CITY OF ALBUQUERQUE

Re: Venice Volleyball Court
5801 Venice Ave. NE
Request for Certificate of Occupancy
Transportation Development Final Inspection
Architect's Stamp dated 02-26-24 (B18-D022)
Certification dated 02-28-25

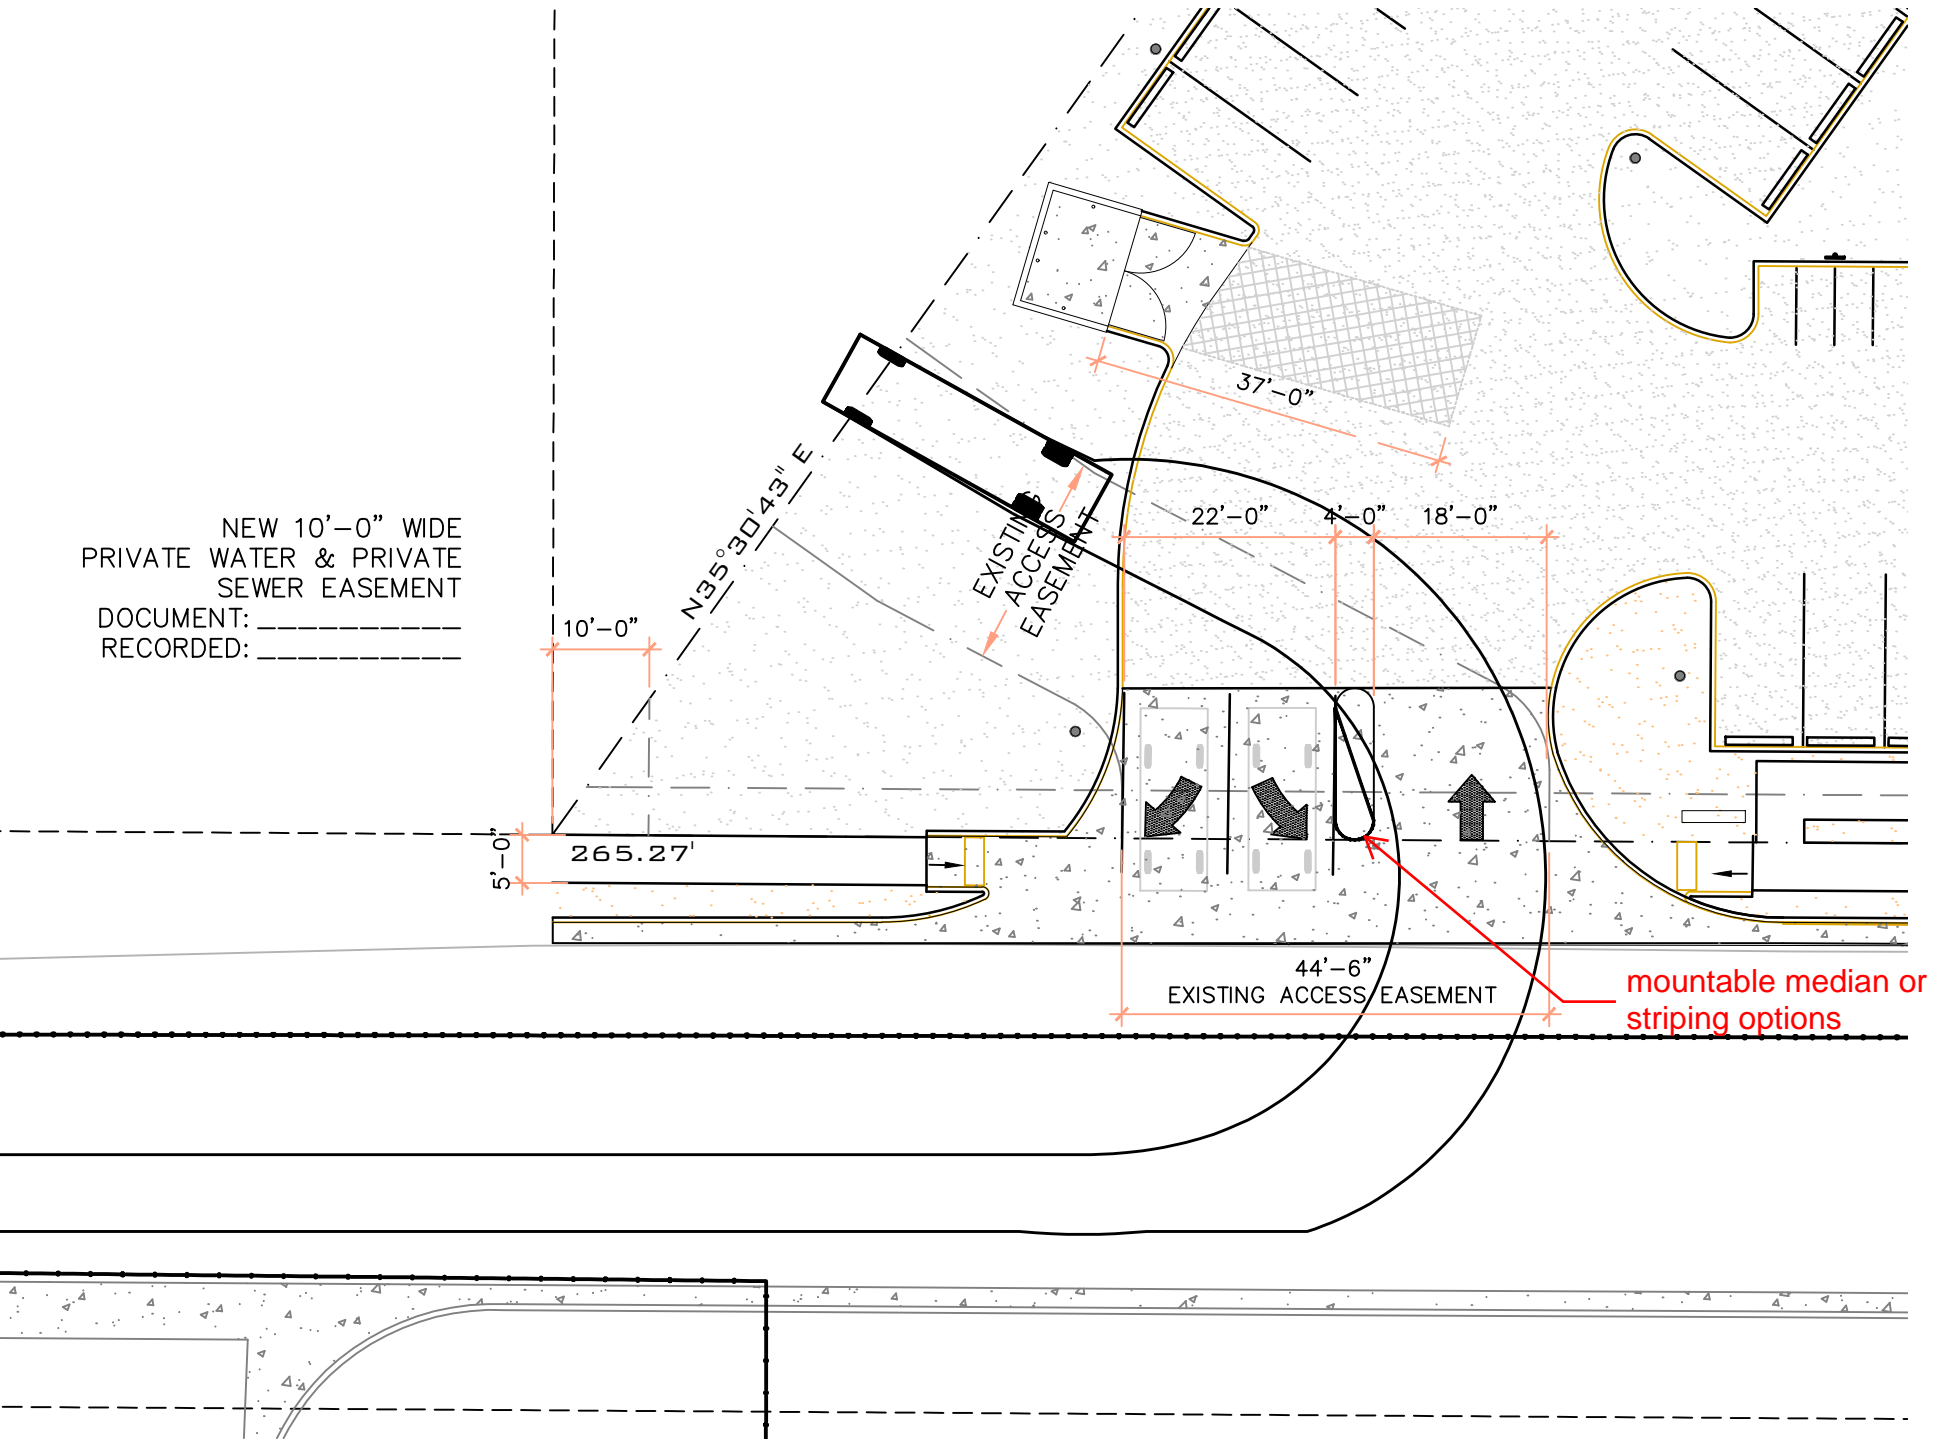
1. The Traffic certification letter must be stamped, signed, and dated by an engineer or architect licensed in the state of New Mexico using the standard language. See attached.
2. The north side parking lot must be constructed.
3. The east side of the site curb and parking bumper must be constructed.
4. The ADA pathway from the public sidewalk to the building entrance must be constructed.

1. The ADA accessible parking sign must have the required language per 66-7-352.4C NMSA 1978 **"Violators Are Subject to a Fine and/or Towing."** Please call out detail and location of signs.
2. The ADA access aisles shall have the words **"NO PARKING"** in capital letters, each of which shall be at least one foot high and at least two inches wide, placed at the rear of the parking space so as to be close to where an adjacent vehicle's rear tire would be placed. (66-1-4.1.B NMSA 1978).
3. During my site visit, I observed a lip in the concrete in the transition from the ADA aisle the ADA pathway. This uneven surface creates a tripping hazard. Please grind the area (the highlighted area) to ensure ADA compliance and smooth transition. Also, the parking bumper is missing in the ADA parking spaces.

4. Per approved site plan the public sidewalk width should be 6 ft. However, per the site visit it was only 5 ft. wide. Please ensure the sidewalk is constructed to the required 6 ft width as per approved site plan.
5. Please provide the direction arrows at the site access as shown in the site plan.
6. Anchor down Bike Rack.
7. Sidewalk culvert at the west side of the site access is missing.
